Our Case Number: ACP-324328-26

Re: Proposed Tullan Strand Facility Centre for Water Sports Activities and Accessible Pathway to Tullan Strand Beach
Finner, County Donegal

Re: Objection to Proposed Tullan Strand Water Sports Facility Centre and Associated Compulsory Purchase Order

Figure 3.5 Works Area 3. Provision of a new pathway and boardwalk to the beach and provision of a hard finished roadway to provide for a replacement cattle crush and access for emergency vehicles to a drop off collection point close to the access to the beach.

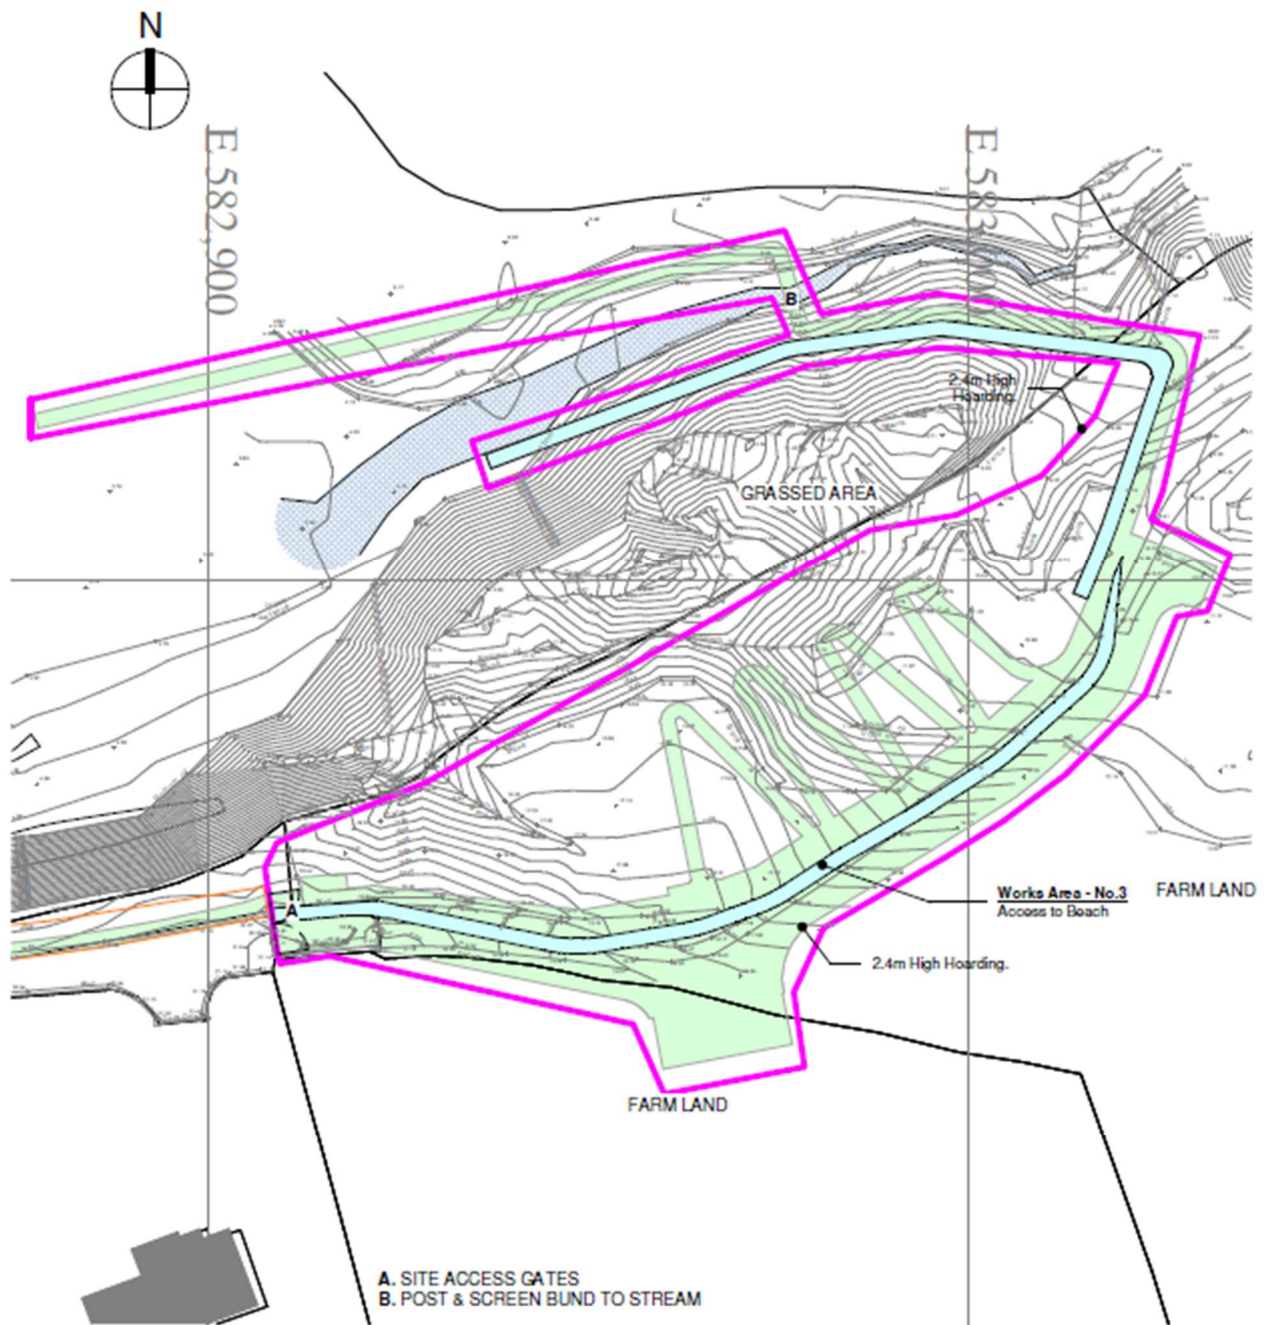
Having reviewed the proposed plans, I have serious concerns regarding the suggested equestrian route.

The proposed access includes sections of:

- concrete pathways
- timber boardwalks
- shared pedestrian areas

These are wholly unsuitable for horses.

Concrete surfaces create a slip hazard and risk of fall of horse and rider resulting in serious injury, they also create increased concussion on horses' limbs and are not appropriate as an access route to the beach.

Timber boardwalks present additional safety concerns including:

- reduced grip in wet weather

- increased risk of slipping
- hollow sounds beneath horses' feet
- movement within timber structures which many horses find unsettling

Shared pedestrian routes also increase the likelihood of conflict between horses, pedestrians, cyclists and young children.

The proposed alternative route, incorporating concrete surfaces, timber boardwalks and shared pedestrian areas, does not provide a practical or appropriate replacement for the existing access to the beach. Any alternative equestrian route should be designed specifically for horses, taking account of safety, surface suitability and ease of use.
